From: Sarah Burrow <Sarah.Burrow@arun.gov.uk>
Sent: 04 October 2021 14:06
To: Planning.Responses <Planning.Responses@arun.gov.uk>
Cc: Maria Tomalova <Maria.Tomalova@arun.gov.uk>
Subject: RE: Planning Consultation on: FG/145/21/DOC

Engineers Comments Regarding Surface Water Drainage

Application No: FG/145/21/DOC

Site Address: Paddock House 44 Ferringham Lane Ferring BN12 5LU

Drawing Title
**Surface Water Drainage Layout
and Construction Details**

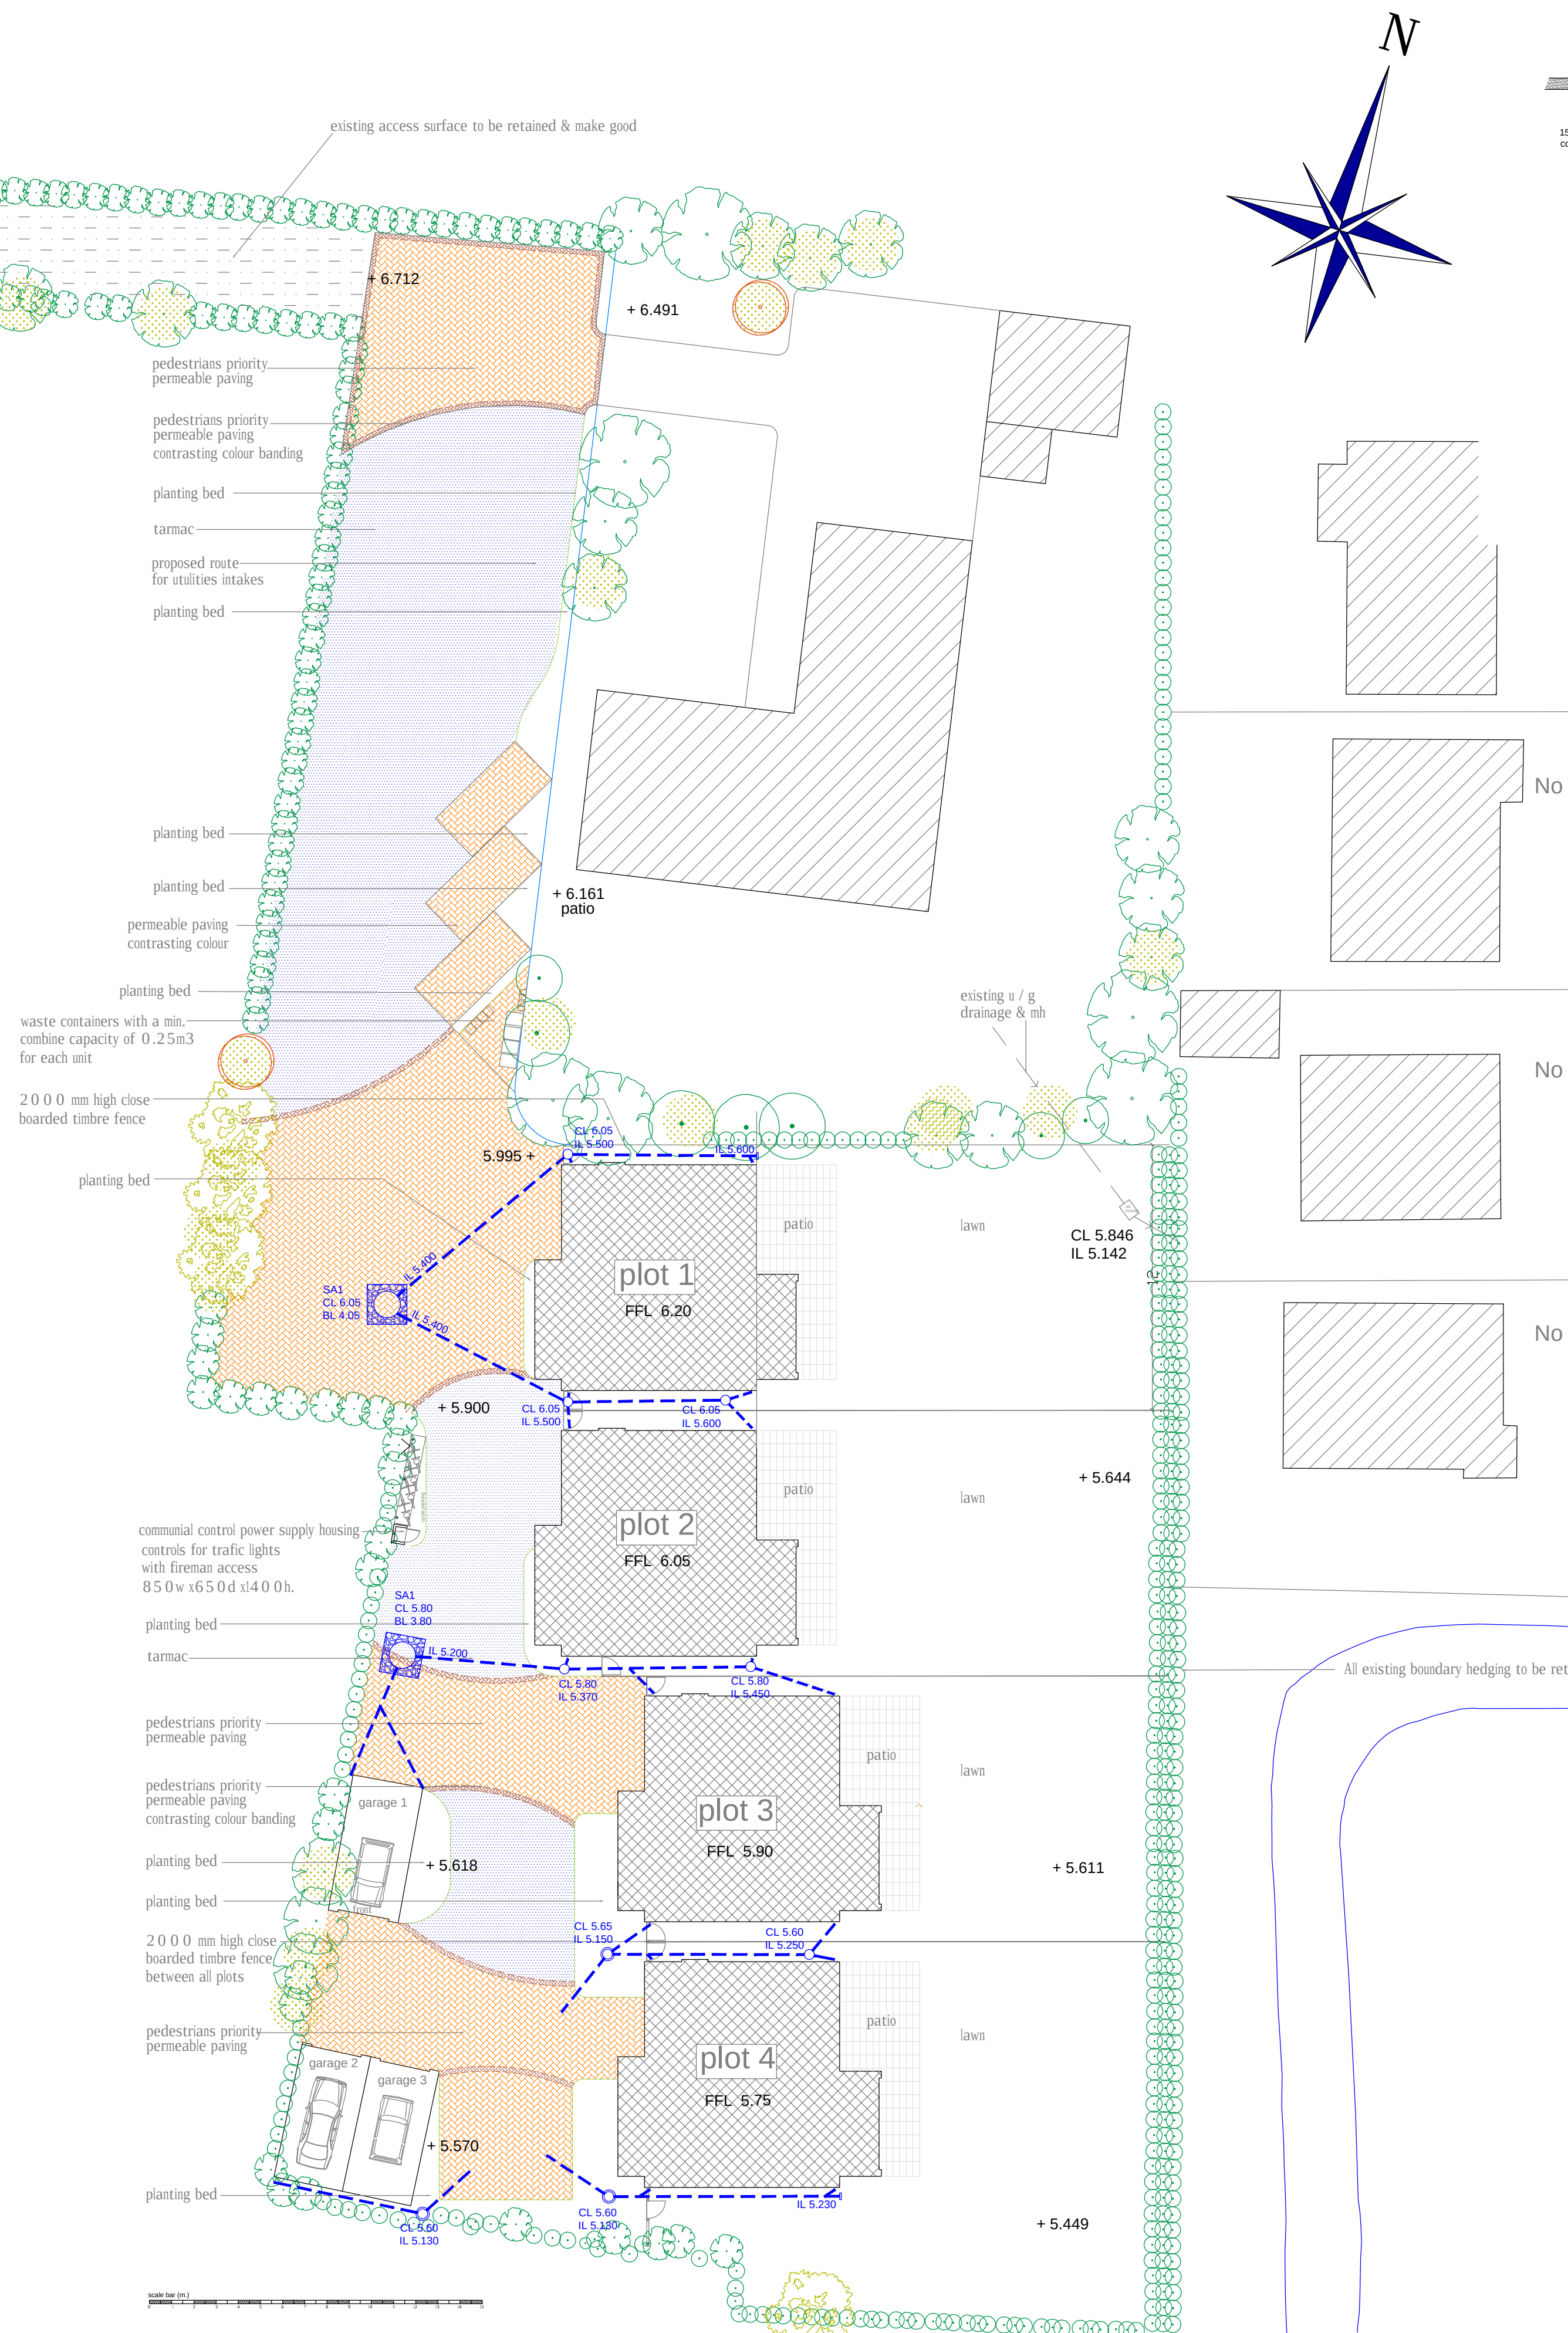
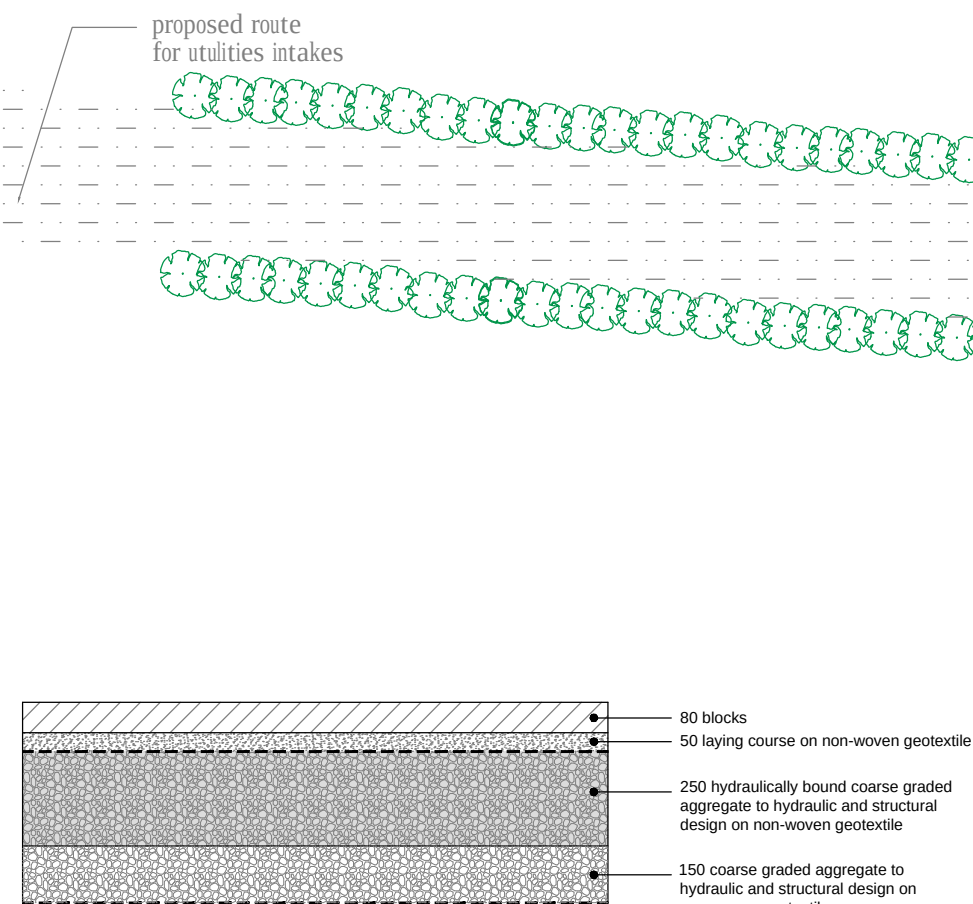
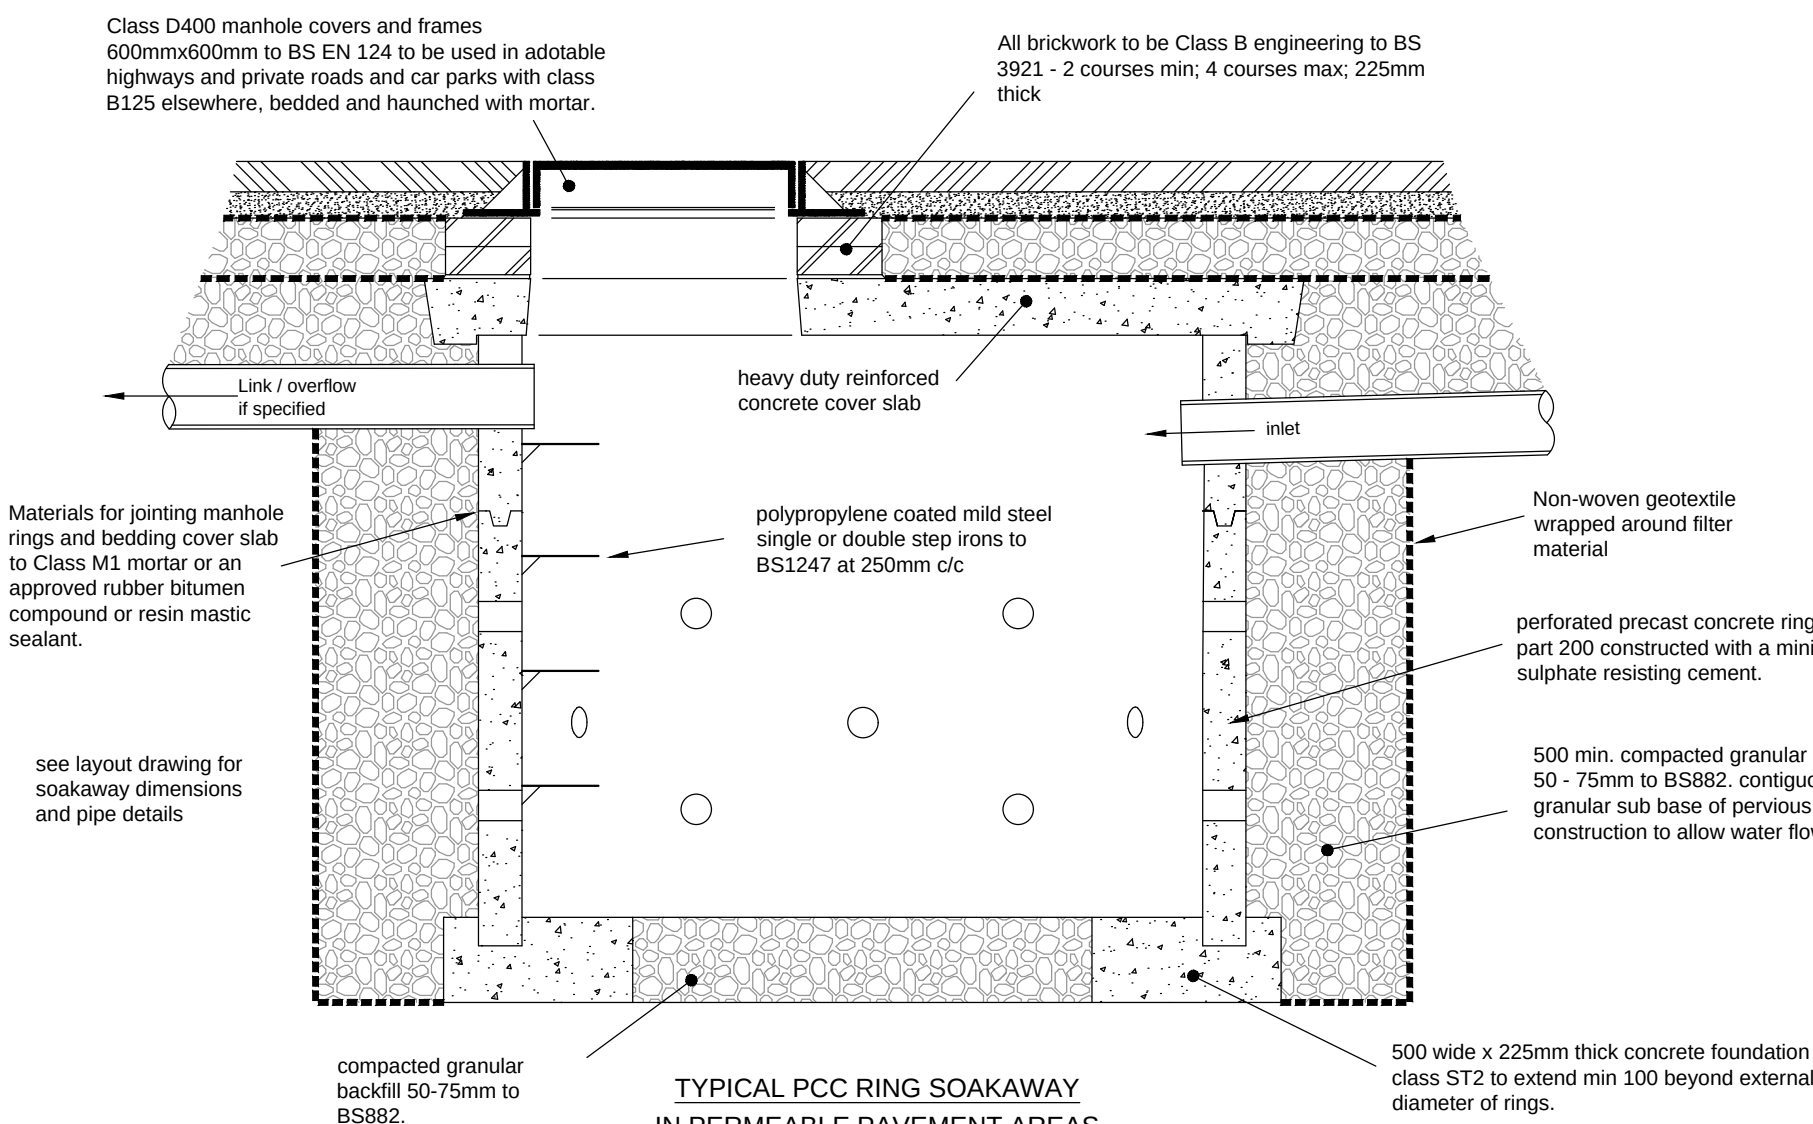
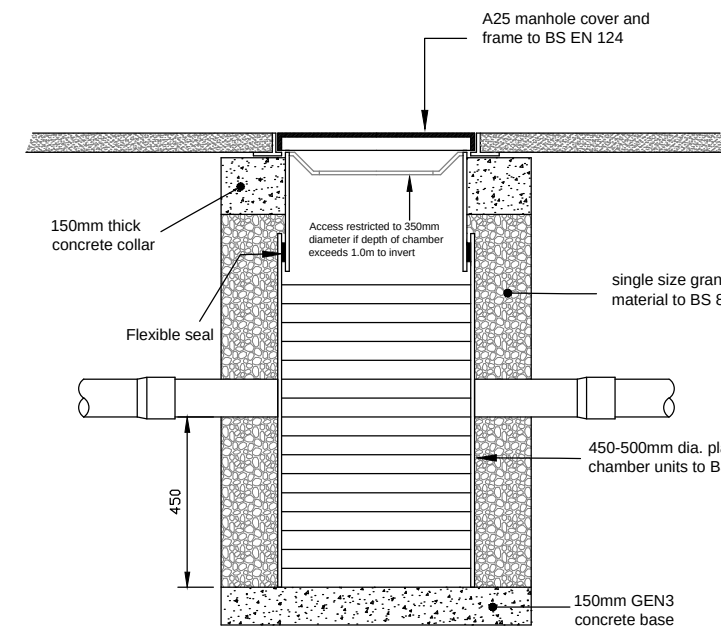
The applicant has supplied the application reference for the previous approval (FG/140/18/DOC) and the relevant documents associated with that approval. Unfortunately these have not been adjusted to account for the new layout and the increased impermeable area on the site. I also have questions regarding the ground investigations that were undertaken under the formerly approved scheme. Please address the following issues/update the plans as follows:

1. No reference is made on the drainage layout to the groundwater levels evidenced on the site. Just that "Groundwater levels are know [sic] to be high in this area". This was picked up on by Laura Gibbons in her consultation on FG/140/18/DOC on 17/08/2018 (uploaded 21/08/2018) and stated that "discussions have been held with the applicant and their engineer. Winter groundwater monitoring was available from a neighbouring site and this has been used for design". No reference has been made to which site this was or what level groundwater was found at.

However, I am aware of groundwater levels of 0.37m bgl (below ground level) at 40 Little Paddocks (another neighbouring property - application reference FG/74/20/DOC) which rendered infiltration unsuitable for that site and would indicate that the soakaways proposed for this site are too deep.

Please present alternative groundwater monitoring data (with application references if not for this site) which illustrates that the infiltration depth proposed is appropriate for the site and if the level is significantly different from that evidenced that 40 Little Paddocks please provide a reasonable explanation for this. In my opinion, site specific groundwater monitoring should have been provided for a site of this size and if a satisfactory solution can not be found without an accurate understanding of the site conditions then it will be requested.

2. I am not satisfied with the timing of the infiltration testing nor the factor of safety used. In this case and only due to the previous approval it will be accepted again, however, this must not be read as precedent set.
3. Calculations need to be updated for the increased impermeable area as a result of the non-material amendment.
4. The Drainage Layout needs to be updated to account for the updated layout. Please pay attention to Note 10 on our Drainage Checklist [download.cfm \(arun.gov.uk\)](#) for the level of detail required on the layout as this will have changed since the previous approval in 2018.
5. Please provide construction detail drawings for all components. Again this requirement is listed in the drainage checklist linked above (under Note 11).
